City of Portland, Maine - Building or Use Permit Application
 389 Congress Street, 04101 Tel: (207) 874-8703, Fax: (207) 874-8716

Permit No: 05-1397	Issue Date:	CBL: 342 B052
------------------------------	--------------------	-------------------------

Past Use: Vacant Land - Willow Knoll subdivision	Proposed Use: Single Family Home/ Move 2160 sq ft single Family Home on to lot add 20' x24 ' Garage	Permit Fee: \$453.00	Cost of Work: \$48,000.00	CEO District:
Proposed Project Description: Move 2160 sq ft single Family Home on to lot add 20' x24 ' Garage		FIRE DEPT: <input type="checkbox"/> Approved <input type="checkbox"/> Denied	INSPECTION: Use Group: Type	
		Signature:	Signature:	
PEDESTRIAN ACTIVITIES DISTRICT (P.A.D.)				
Action: <input type="checkbox"/> Approved <input type="checkbox"/> Approved w/Condition <input type="checkbox"/> Denied				
Signature:		Date:

Dept: Zoning **Status:** Approved with Conditions **Reviewer:** Ann Machado **Approval Date:** 10/24/2005
Note: 10/13/05 Left message with Dana. Need elevation plans, foundation plans & plans for garage. **Ok to Issue:**
10/20/05 Message w/Nick. Still questions on some dimensions.

FLOOR  
GARAGES

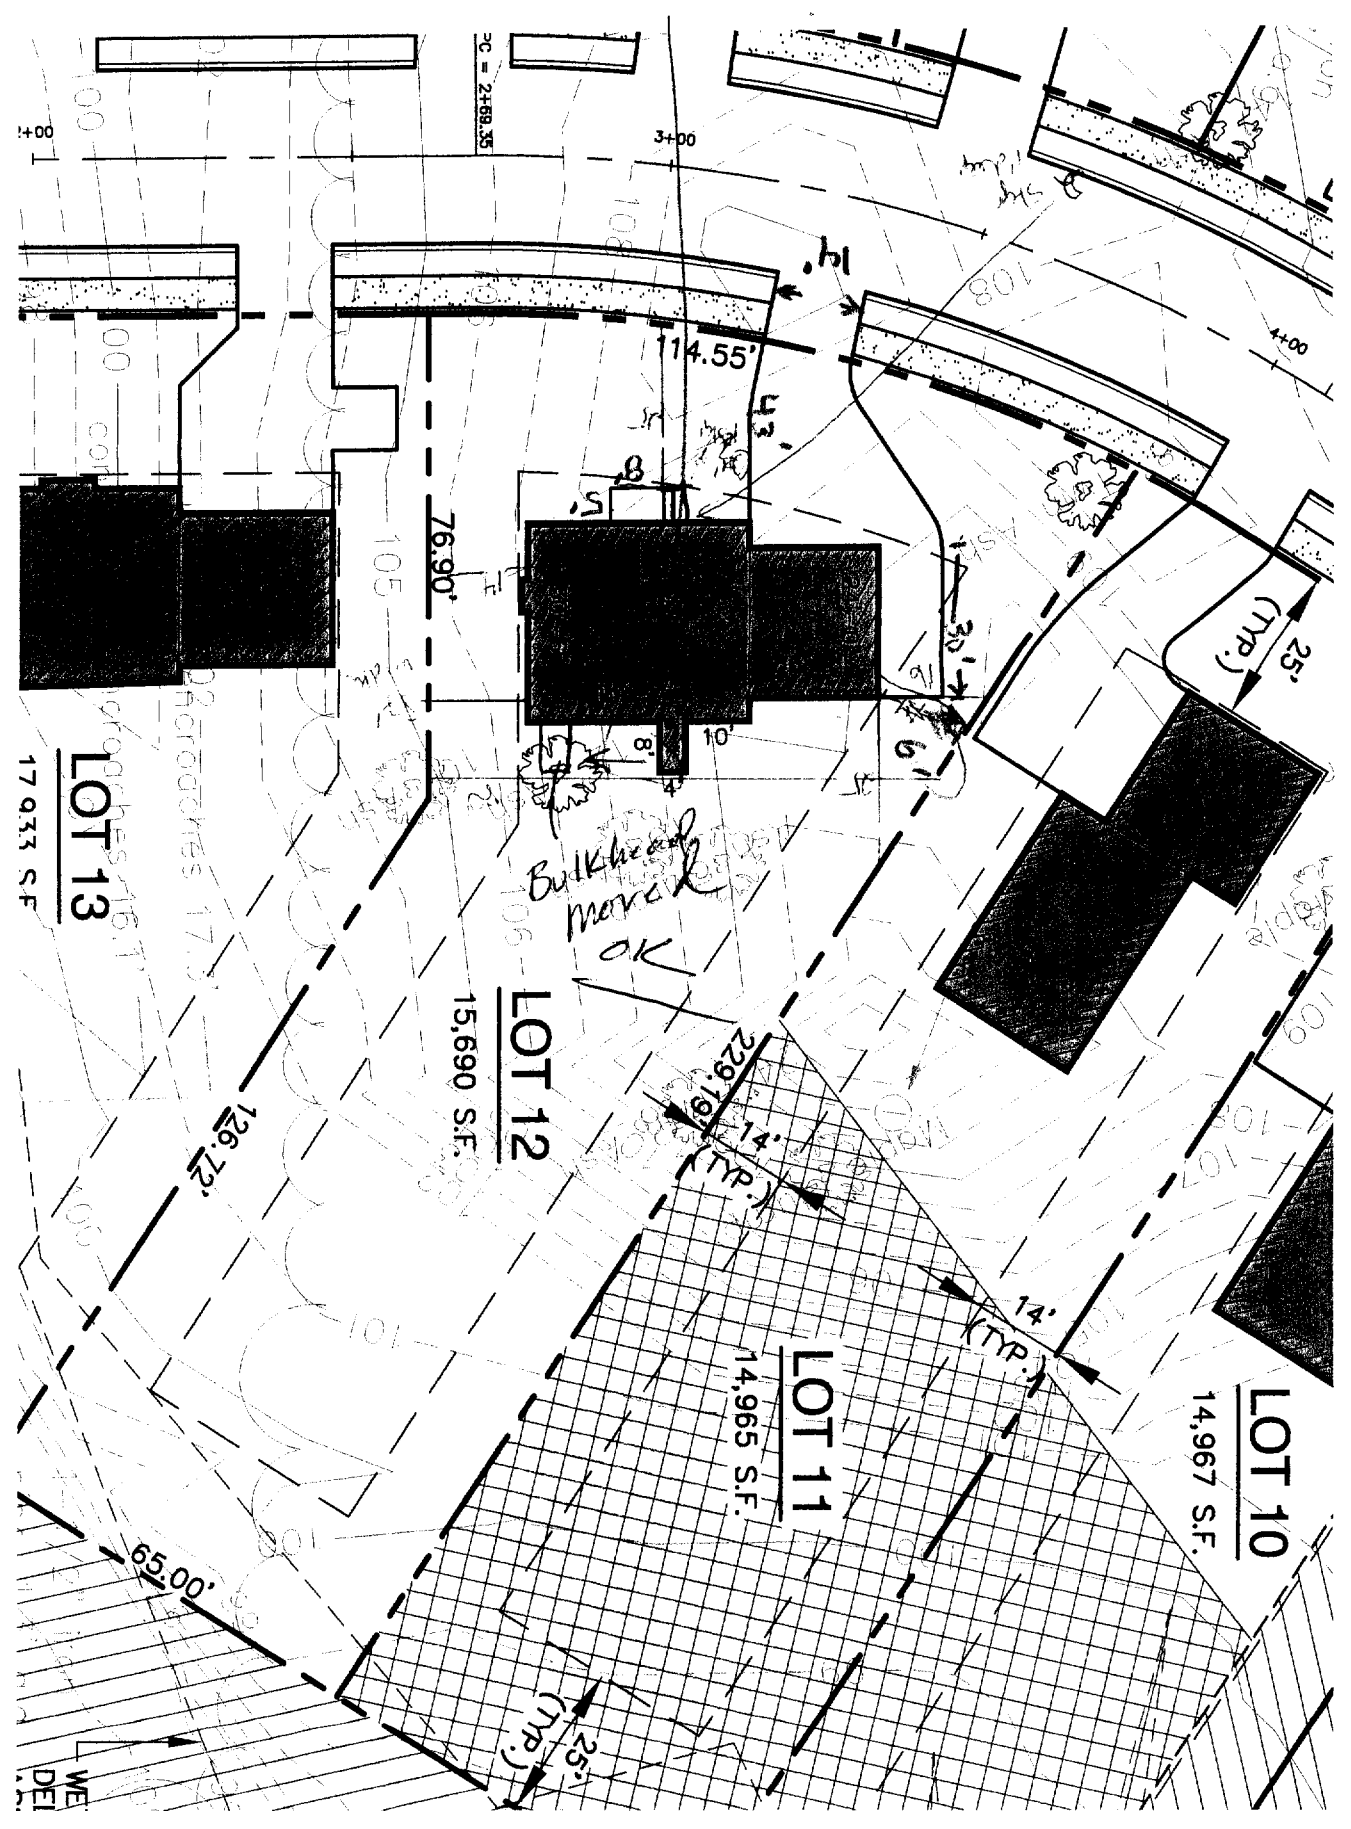
- 1) As discussed during the review process, the property must be clearly identified prior to pouring concrete and compliance with the required setbacks must be established. Due to the proximity of the setbacks of the proposed addition, it may be required to be located by a surveyor.
- 2) Separate permits shall be required for future decks, sheds, pools, and/or garages.
- 3) This property shall remain a single family dwelling. Any change of use shall require a separate permit application for review and approval.
- 4) This permit is being approved on the basis of plans submitted. Any deviations shall require a separate approval before starting that work.

Sheet #1

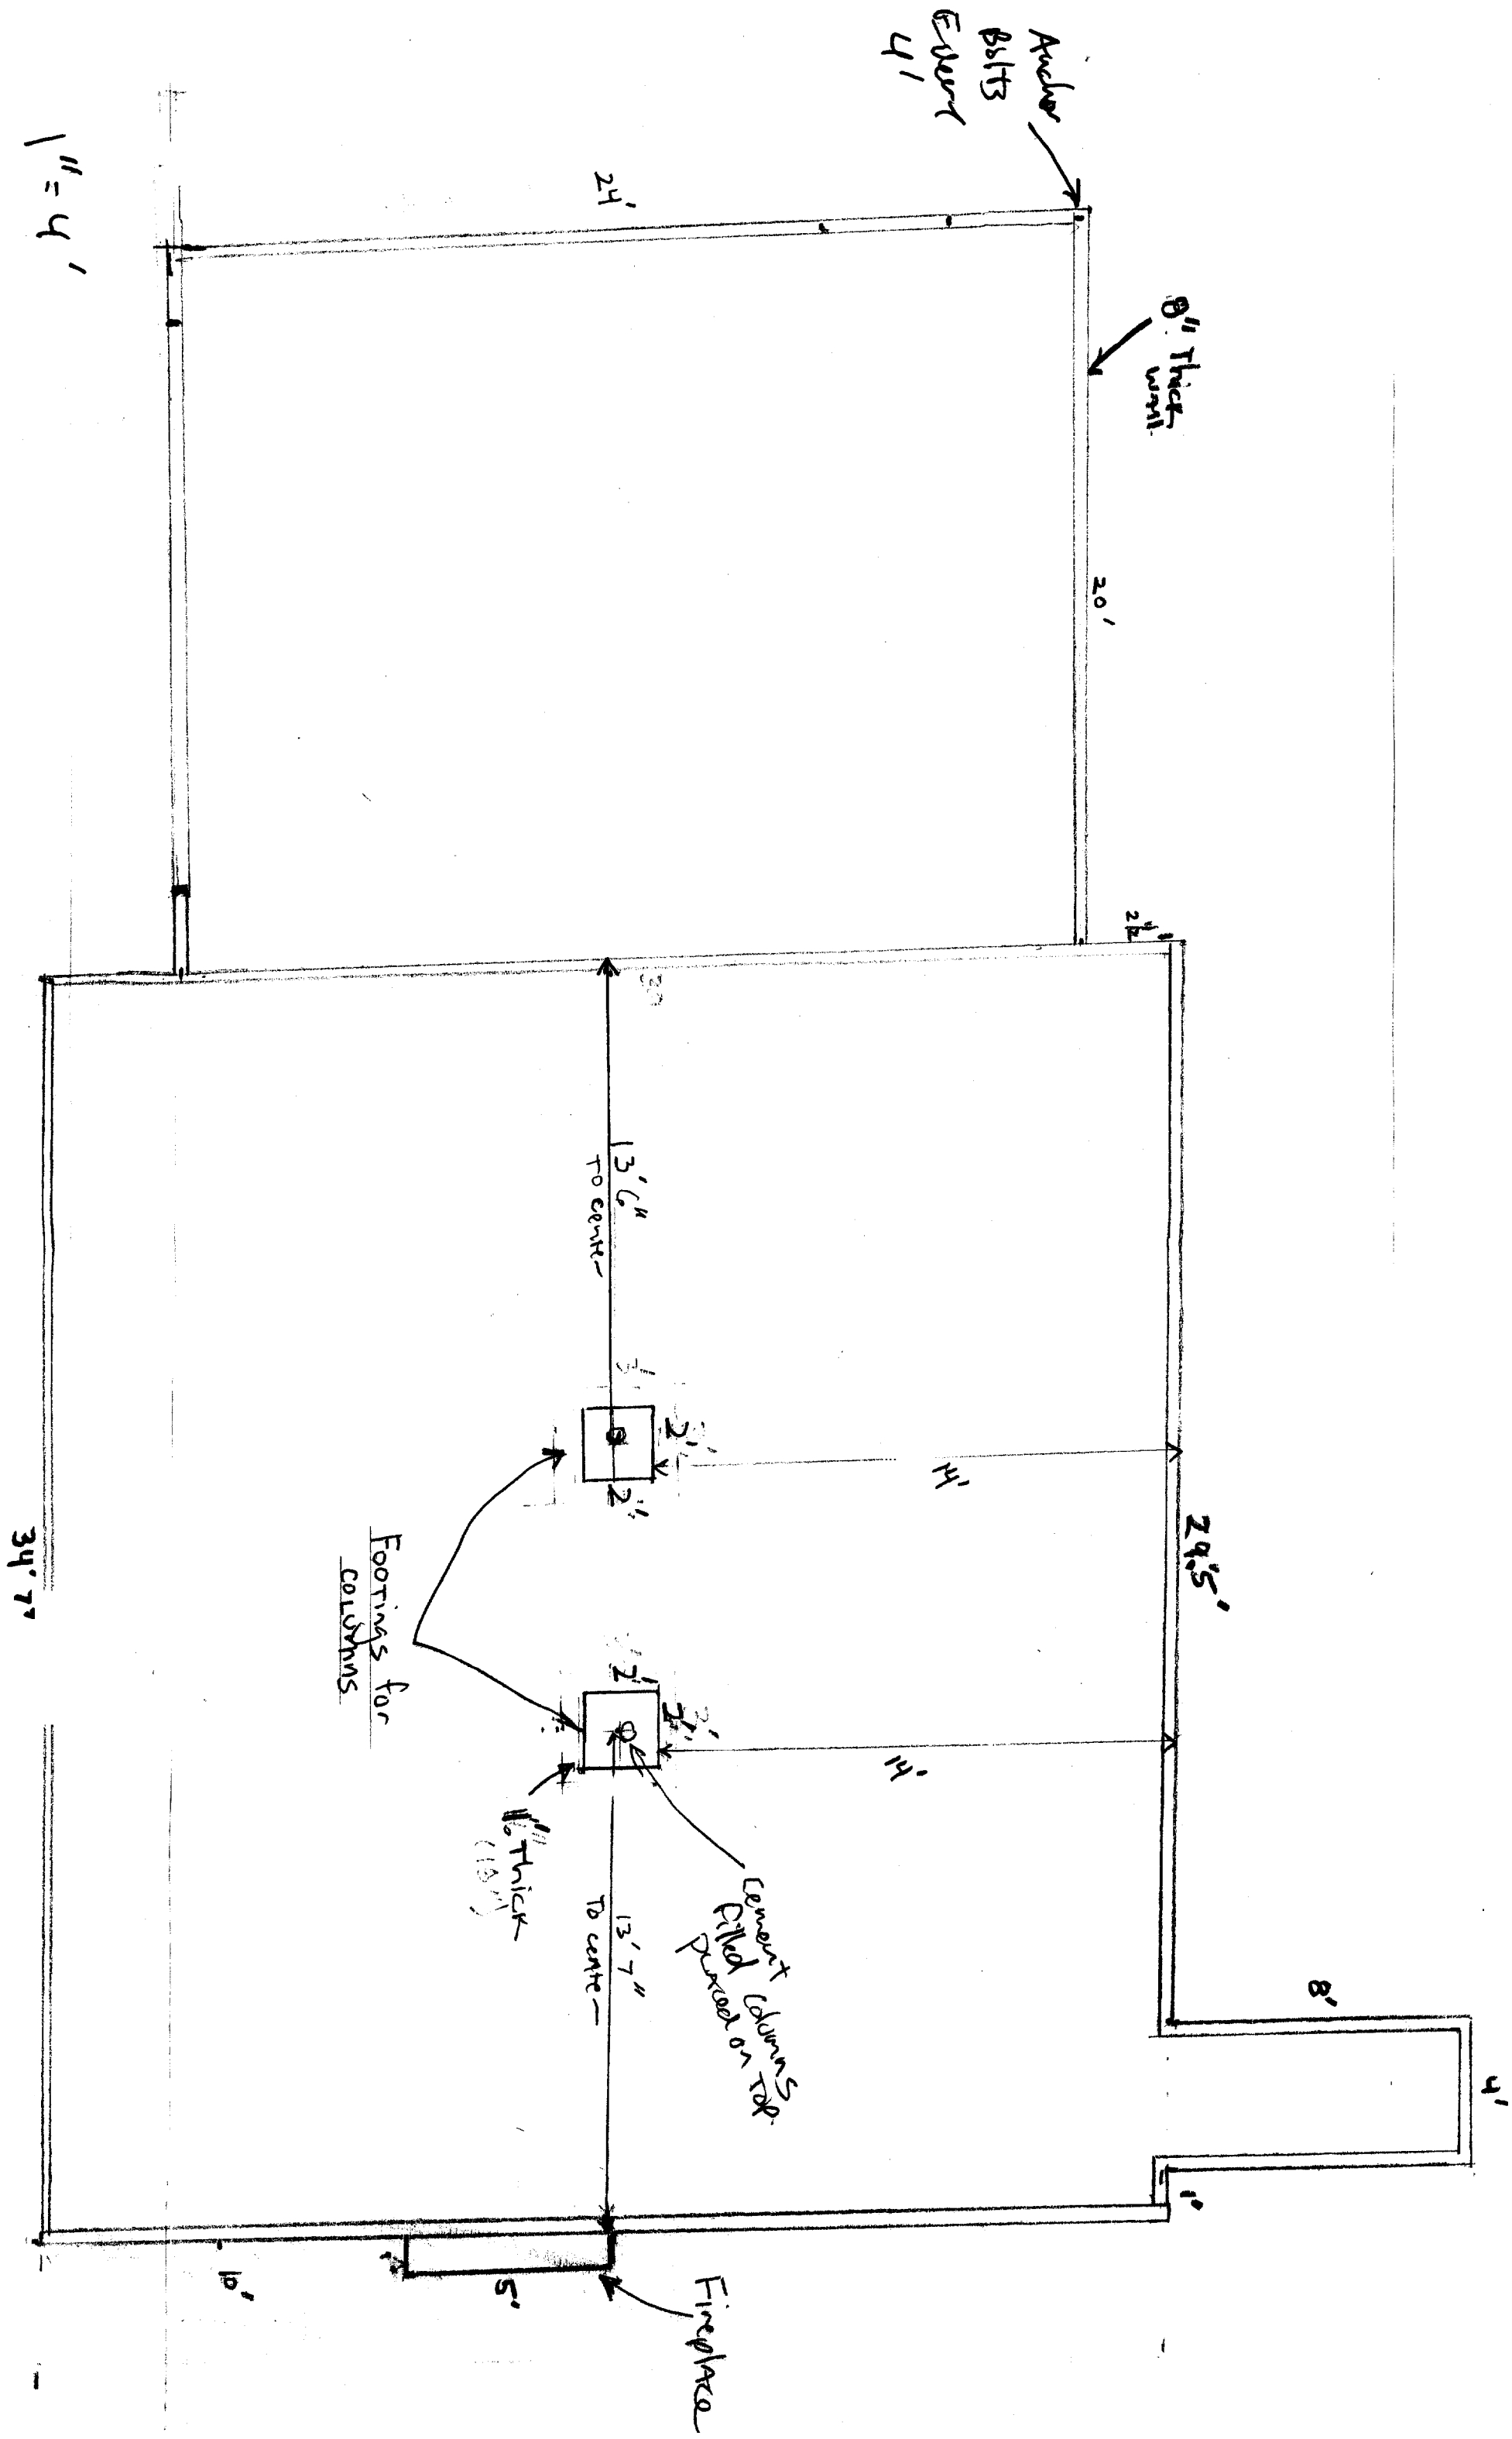
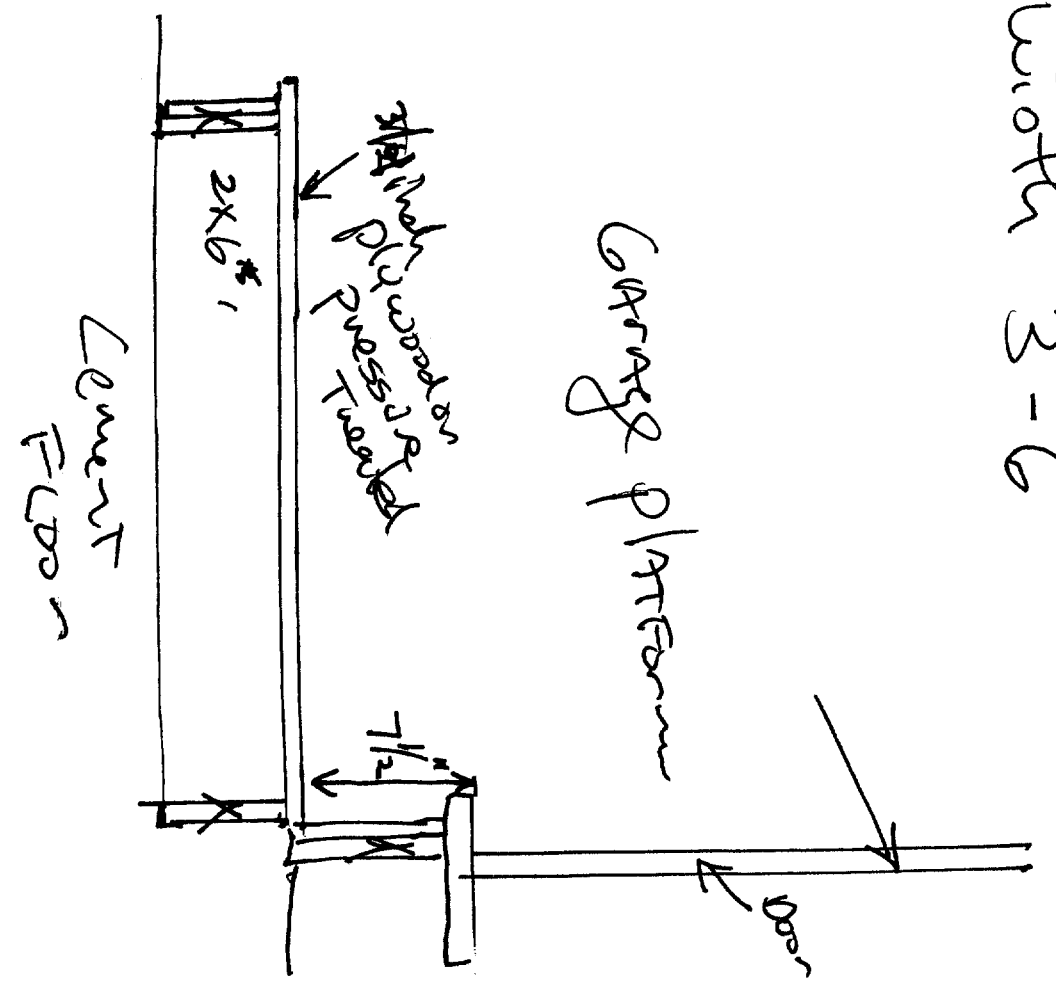
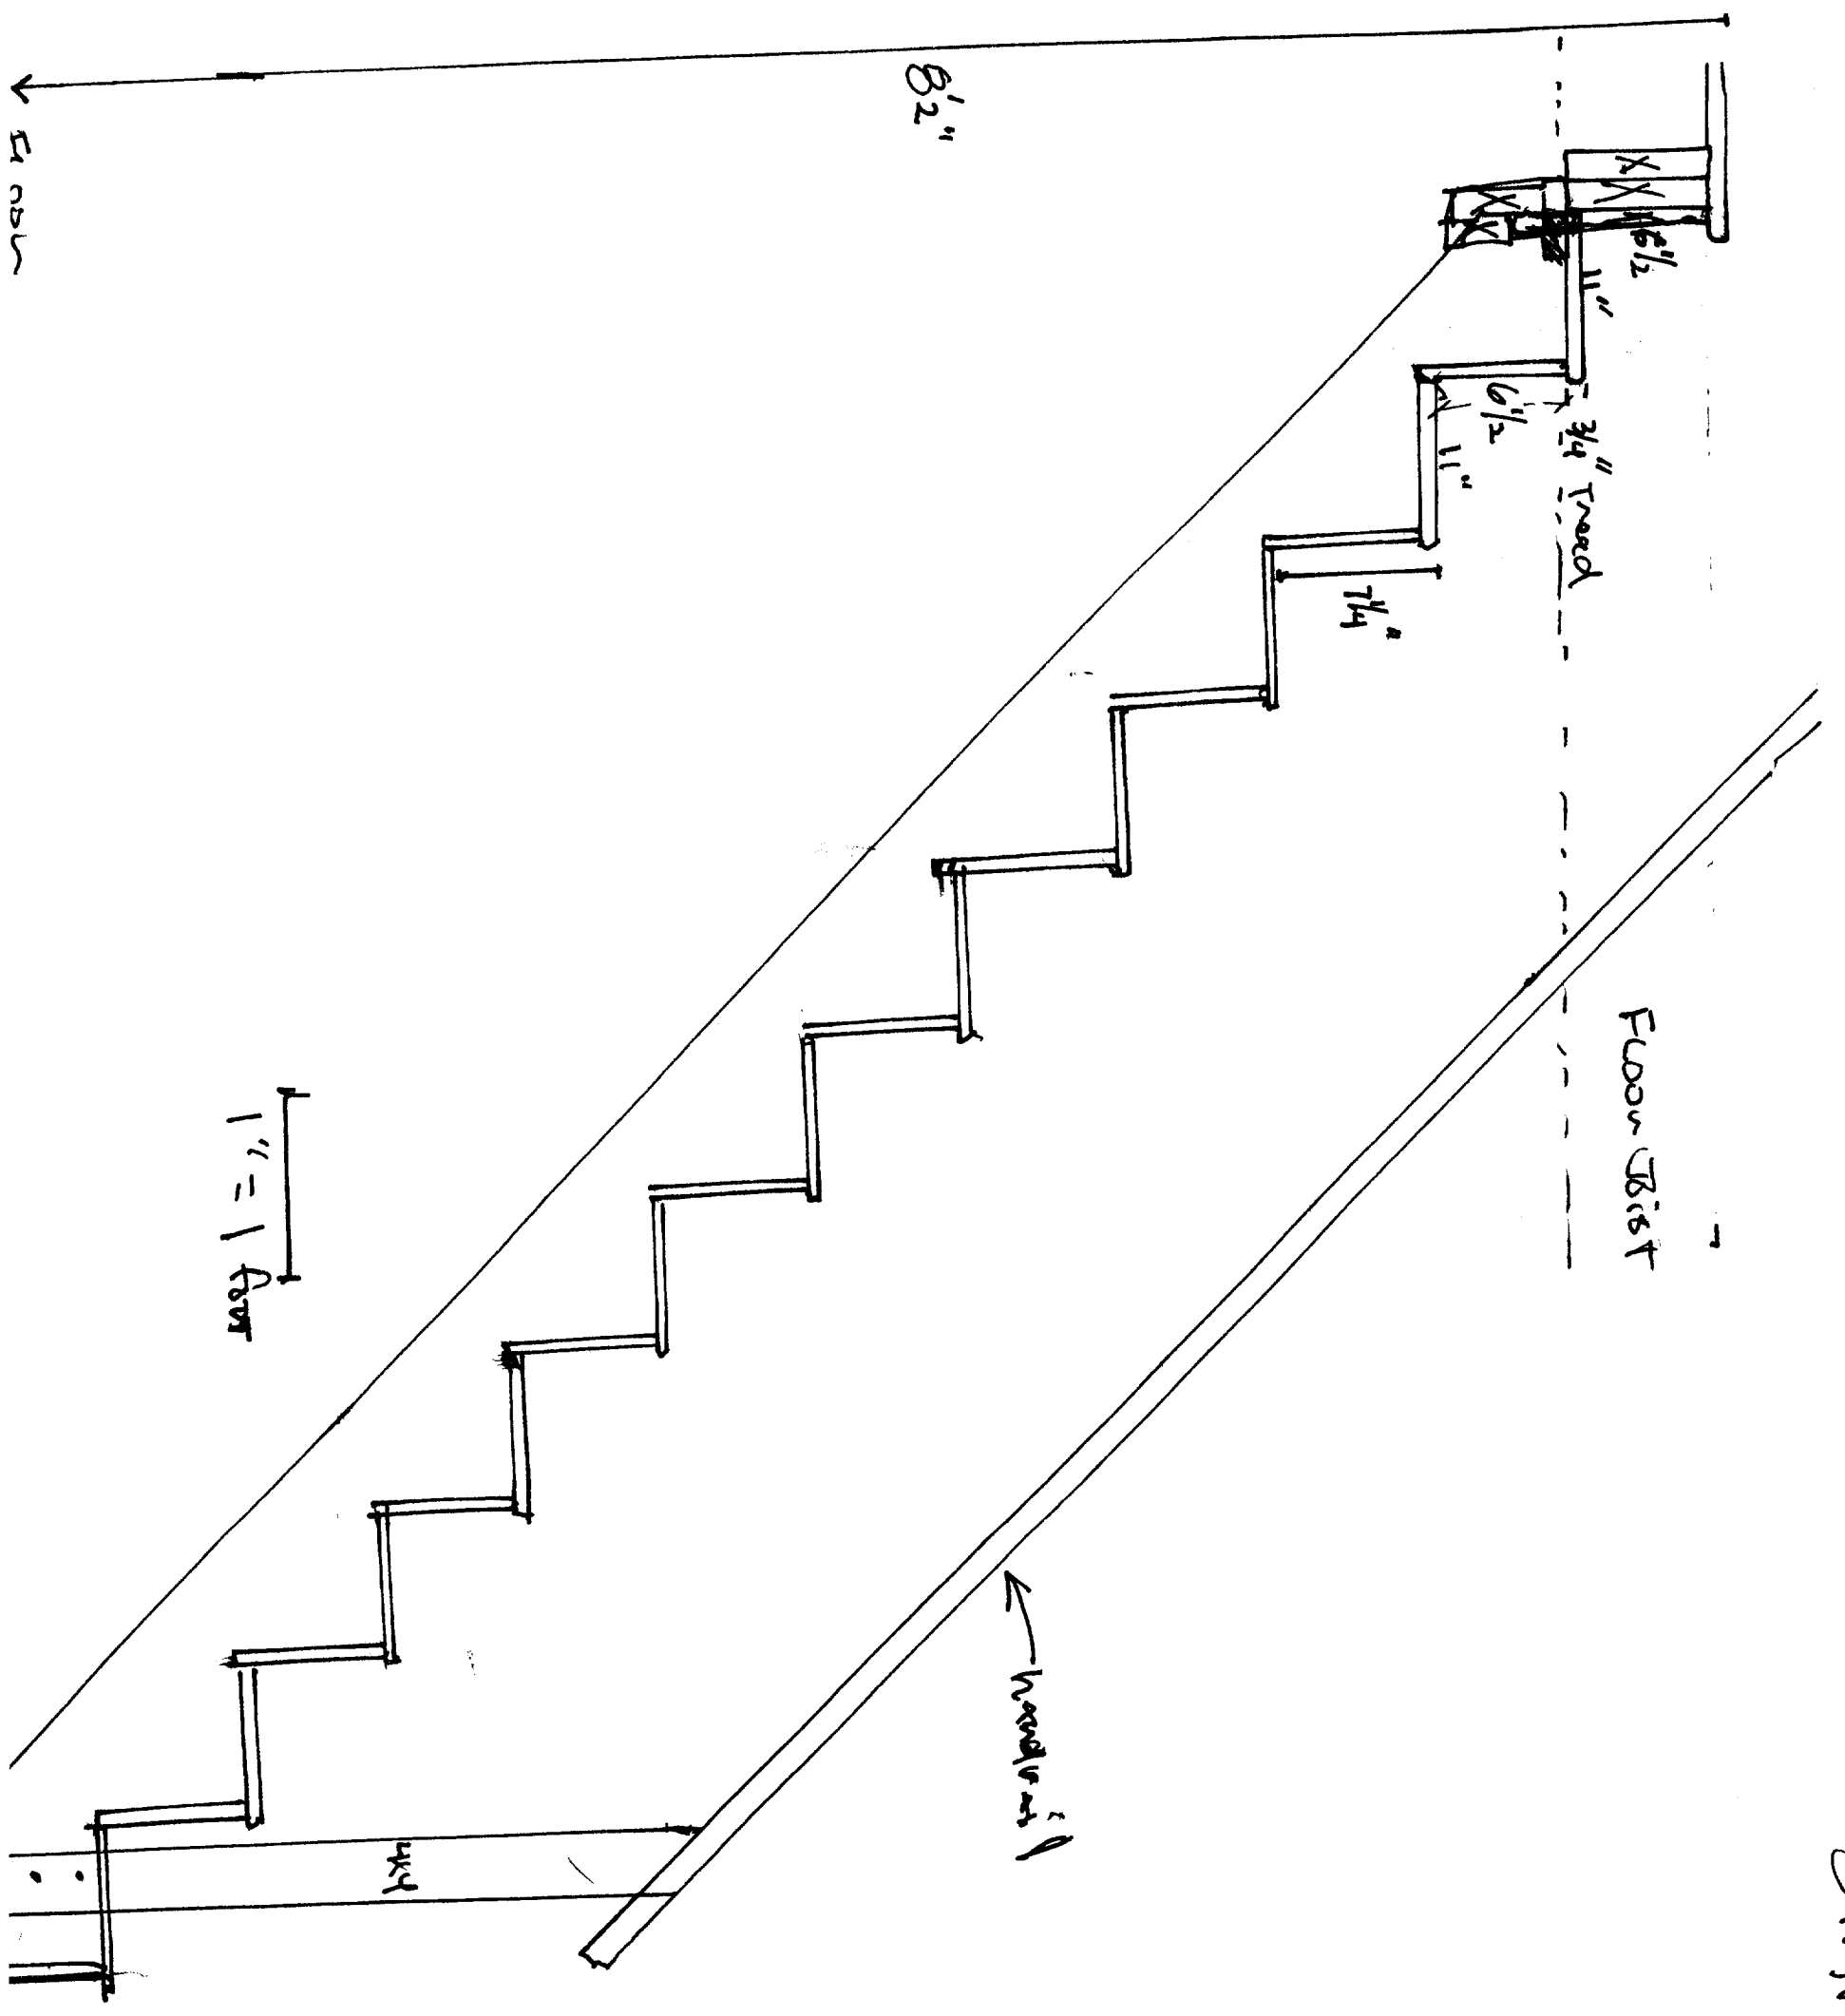
- 1) Separate permits are required for any electrical, plumbing, or heating.
- 2) The basement is NOT approved as habitable space. A code compliant 2nd means of egress must be installed in order to change the use of this space.
- 3) As discussed, the location of the lally columns are in the same location as they were prior to relocation of the structure.
